EN010010 - Application by Medworth CHP Limited for an Order Granting Development Consent for the Medworth Energy from Waste Combined Heat and Power Facility (Medworth EfW CHP Facility)

Response to Section 51 advice (Examination Library Reference PD-003) and application document updates

**LAND PLAN  
SHEET 5 OF 17**

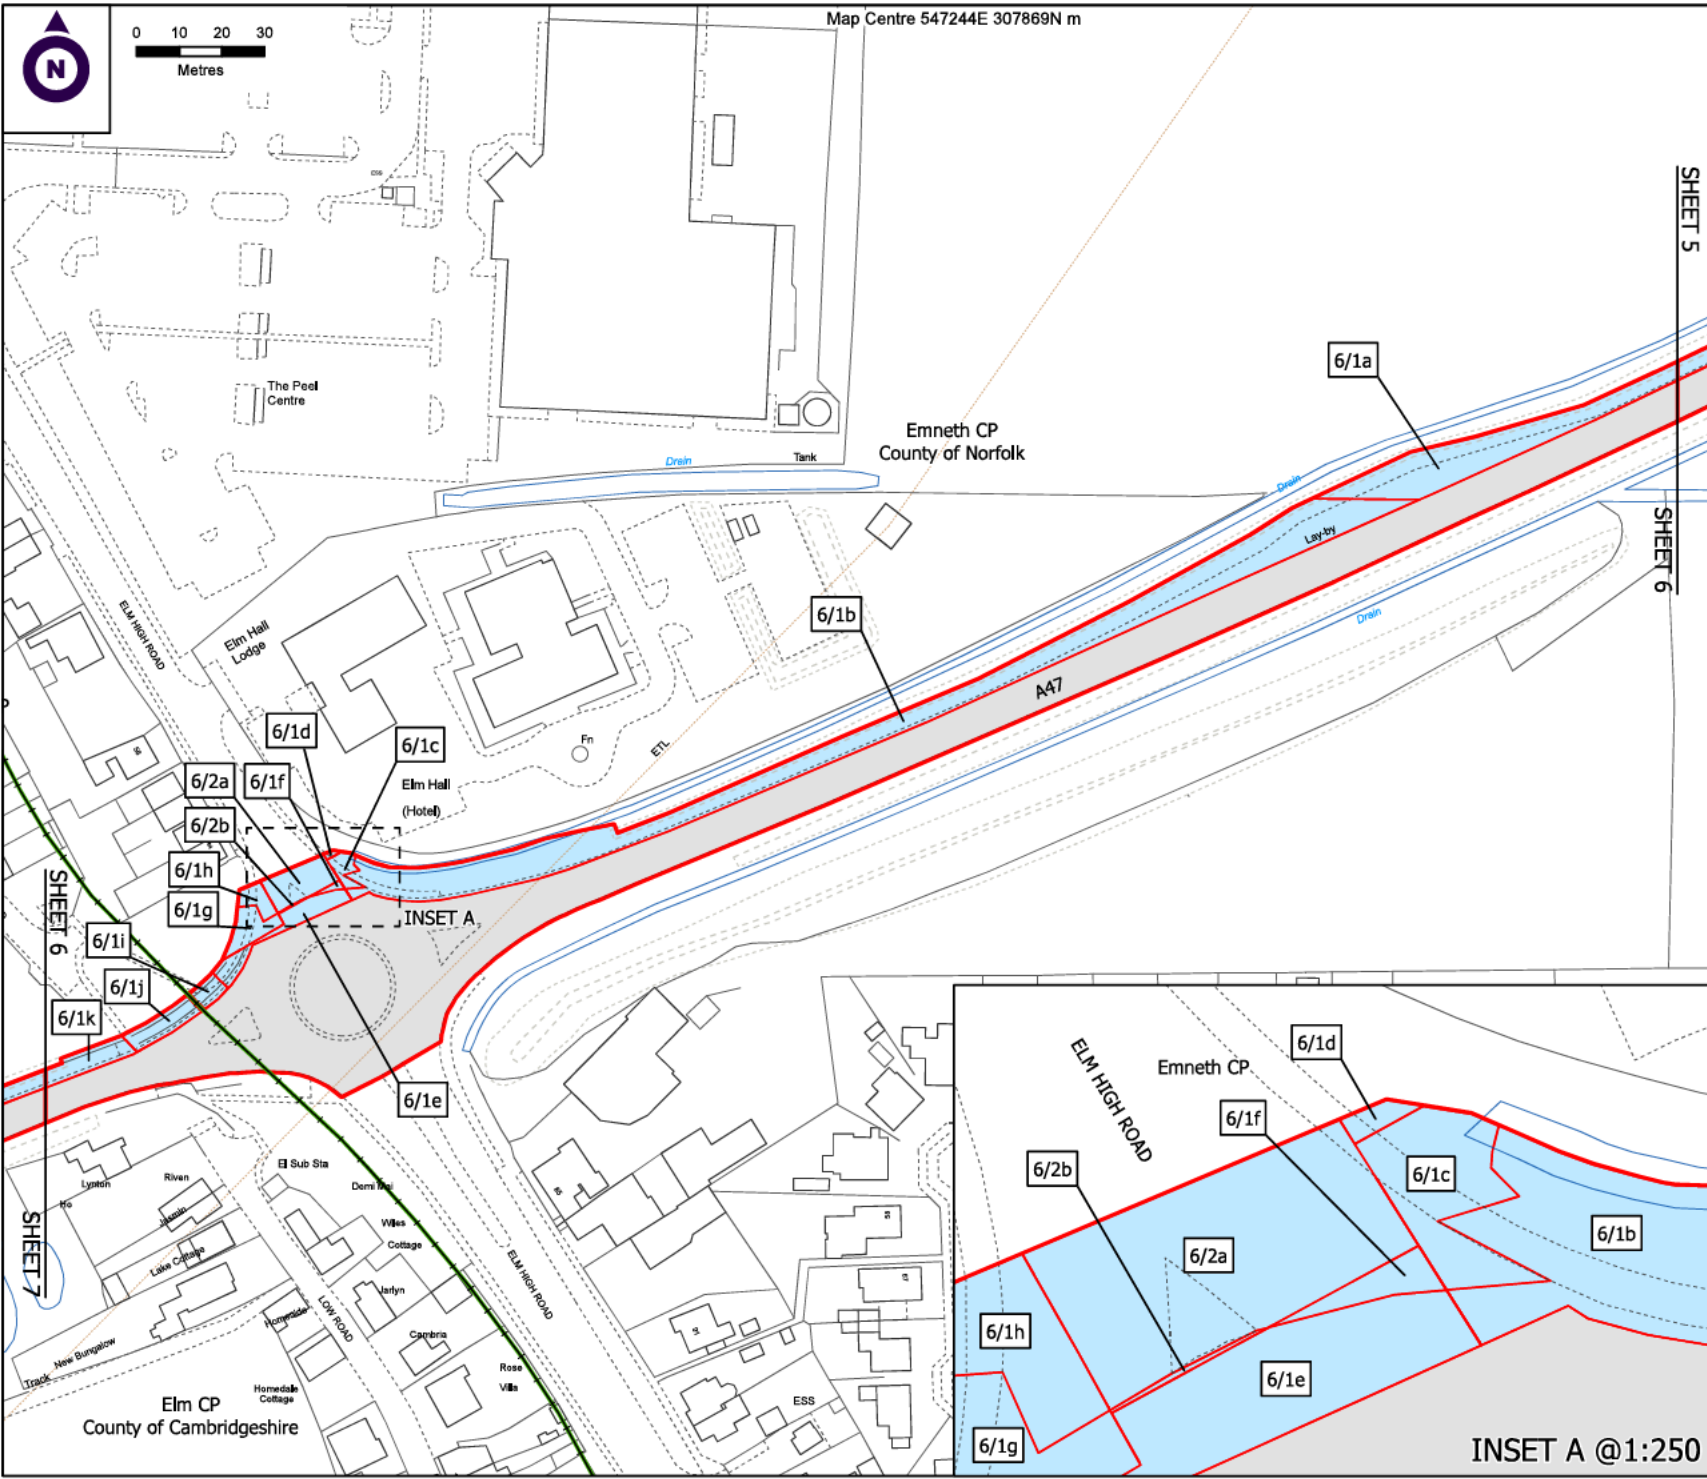
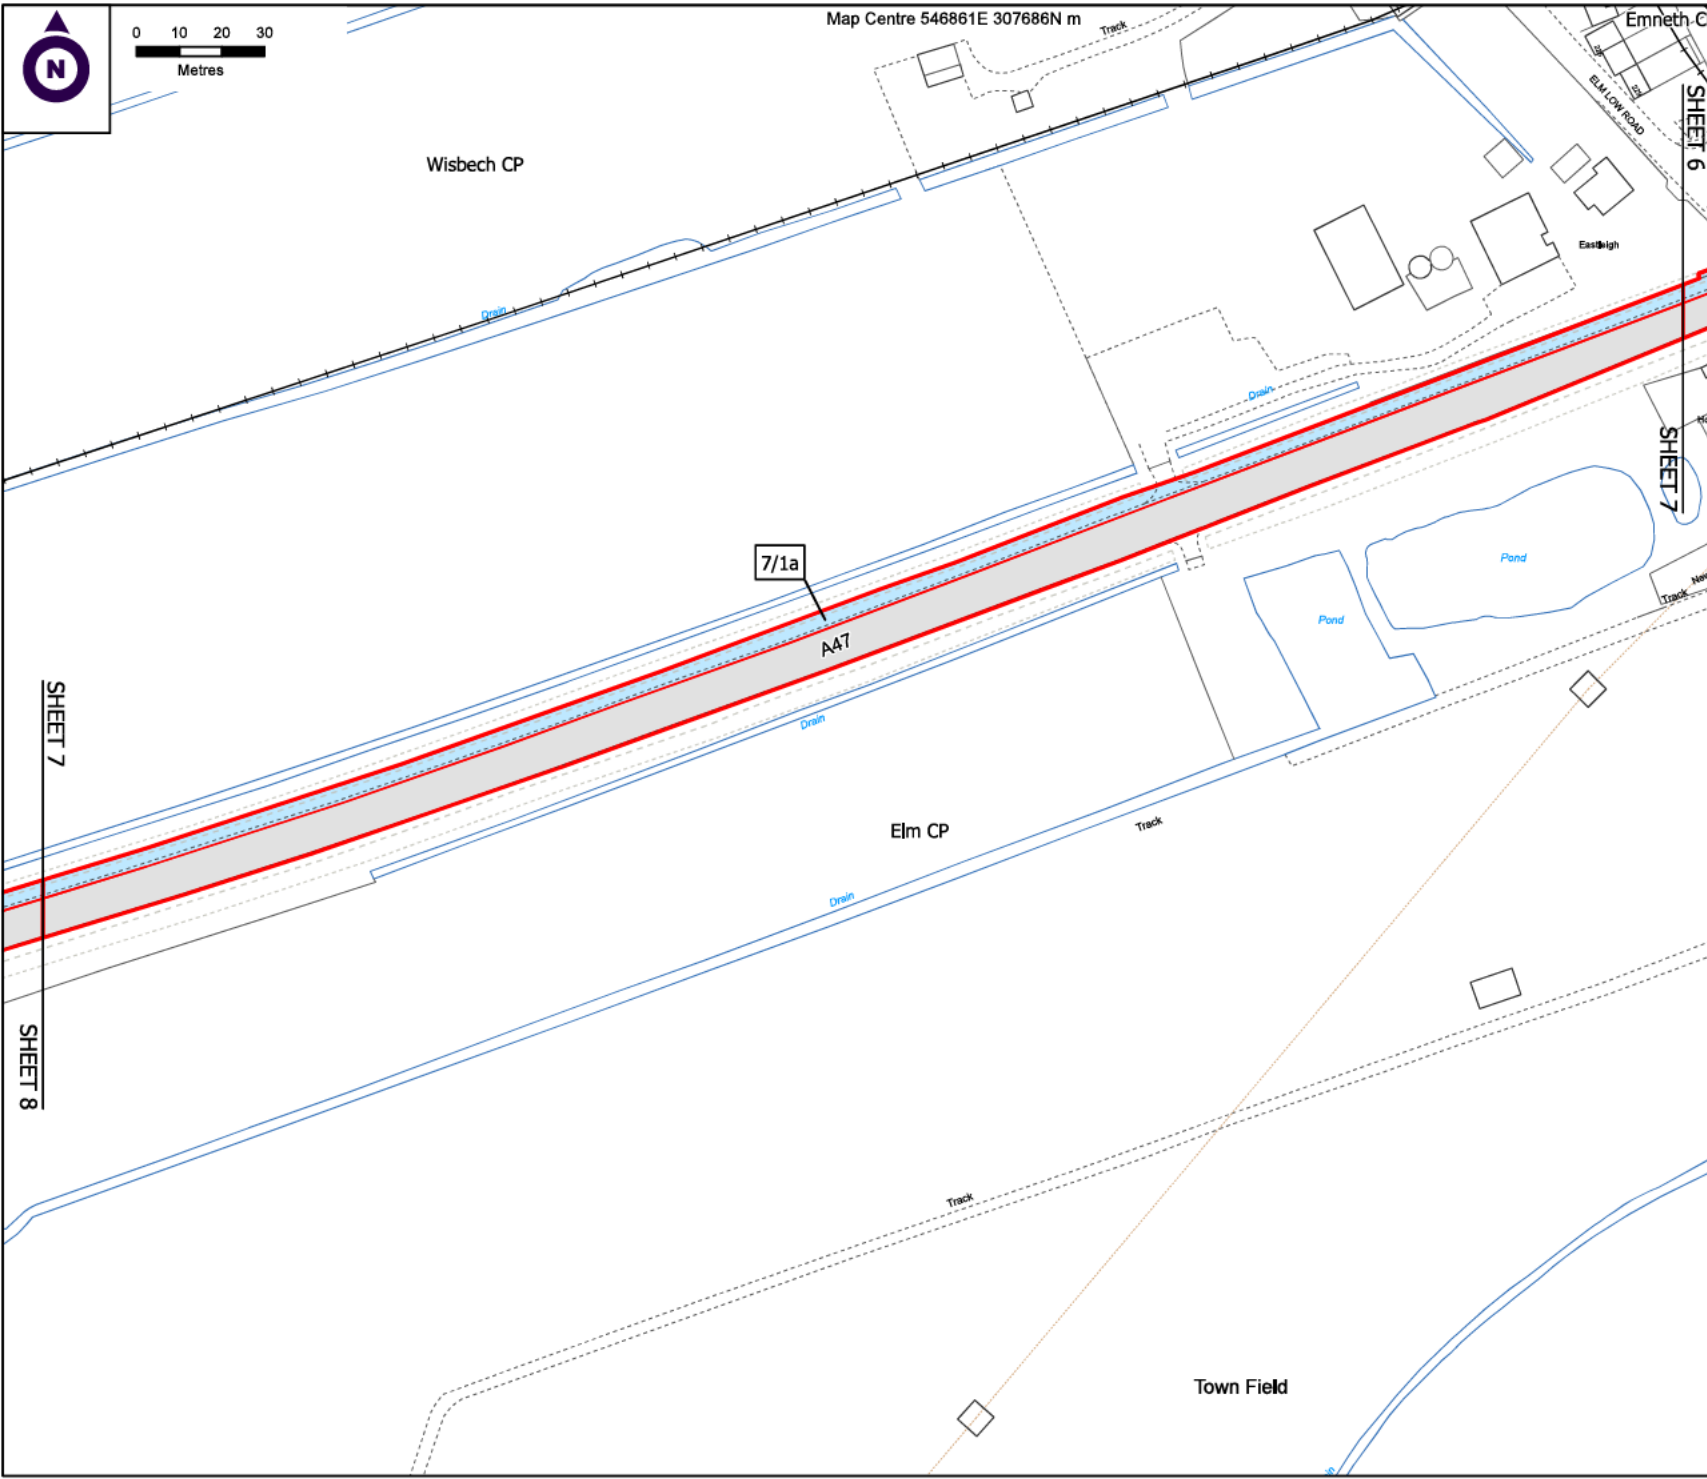
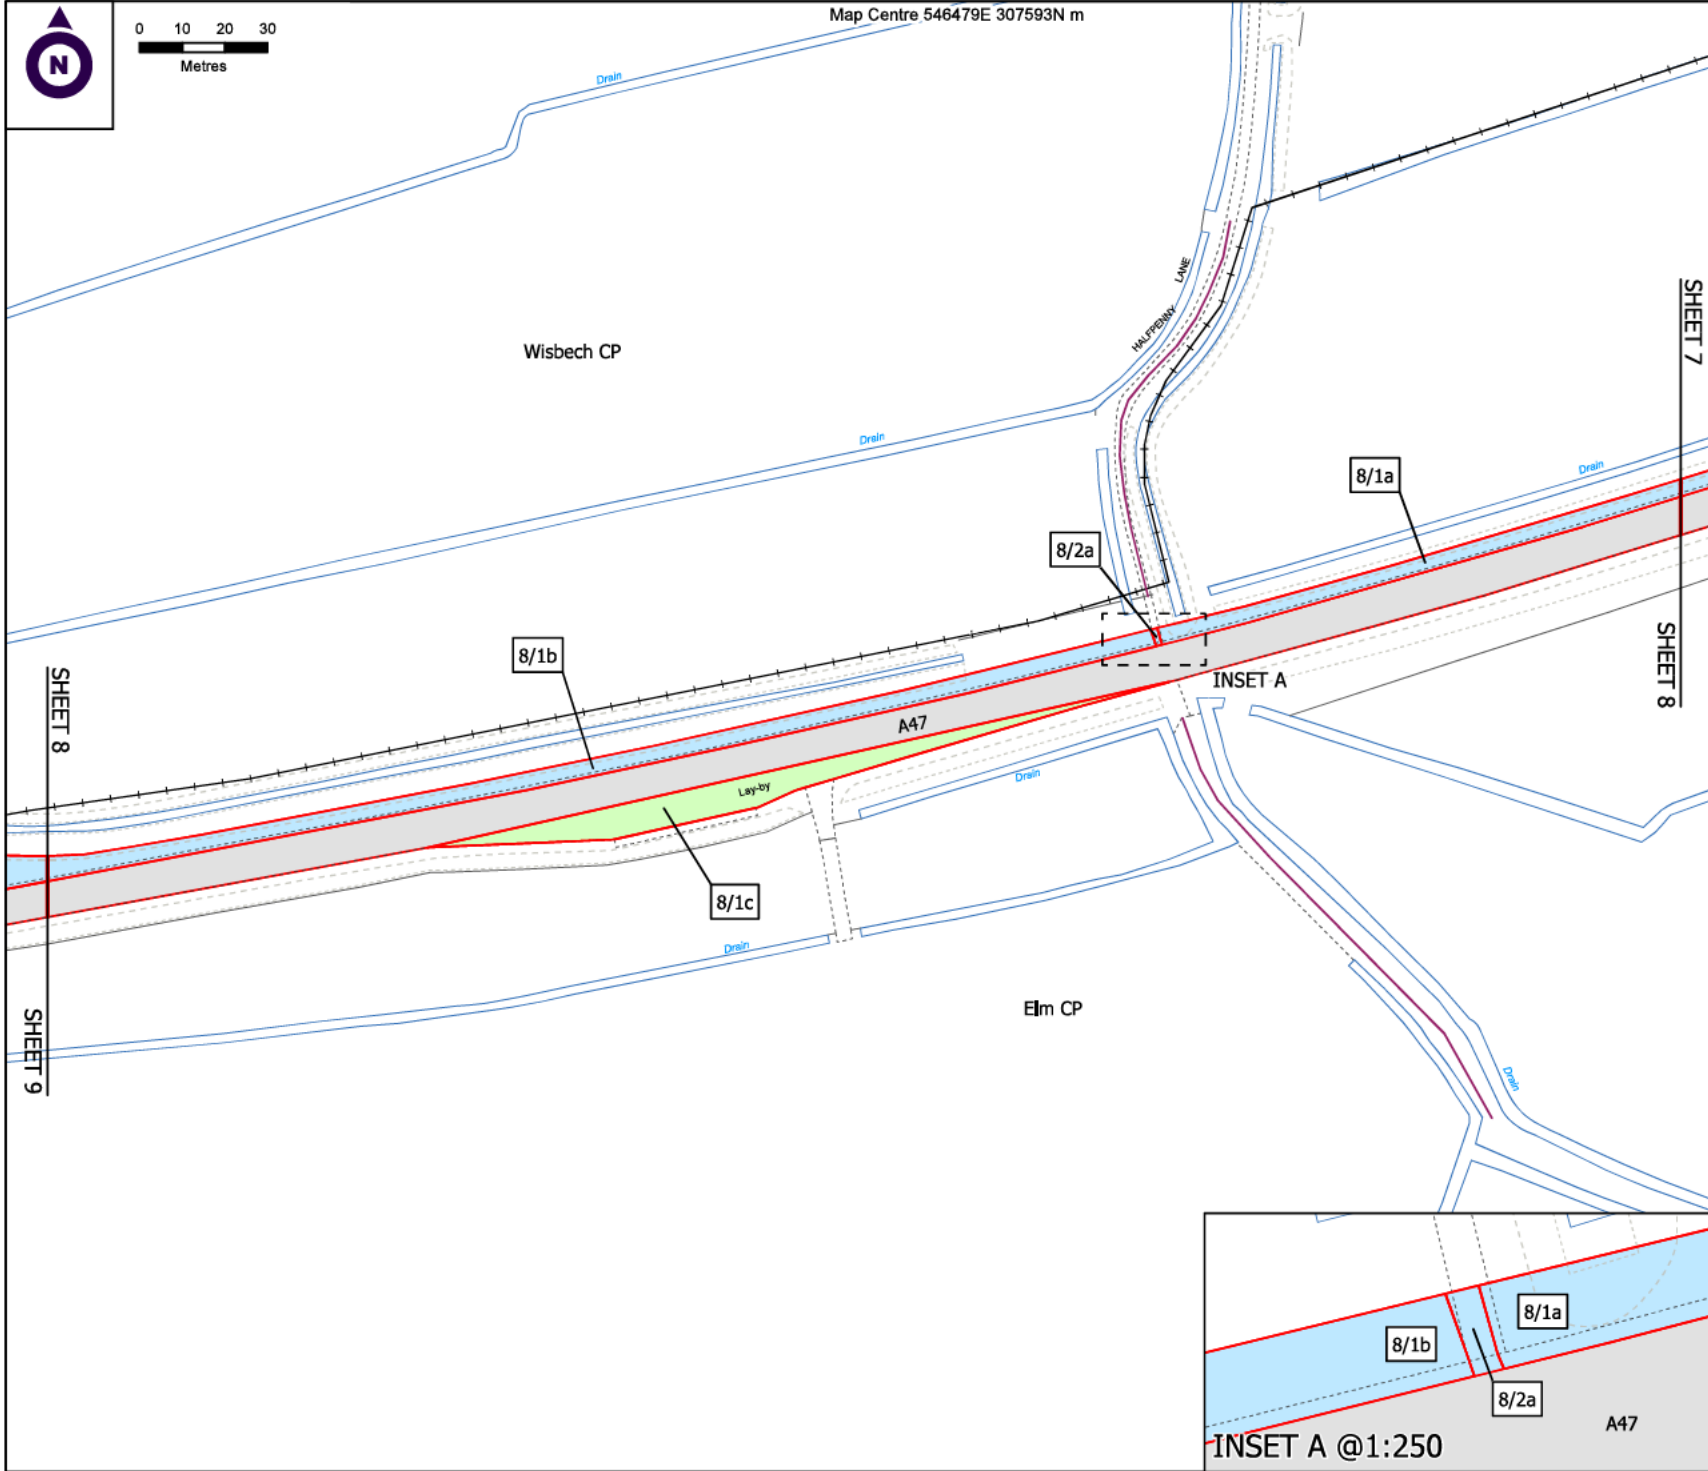
The Land Plans (**Volume 2.2**) (APP-006) have been updated so the red line demarking each plot is more visible under the cut line where the plot spans more than one sheet.
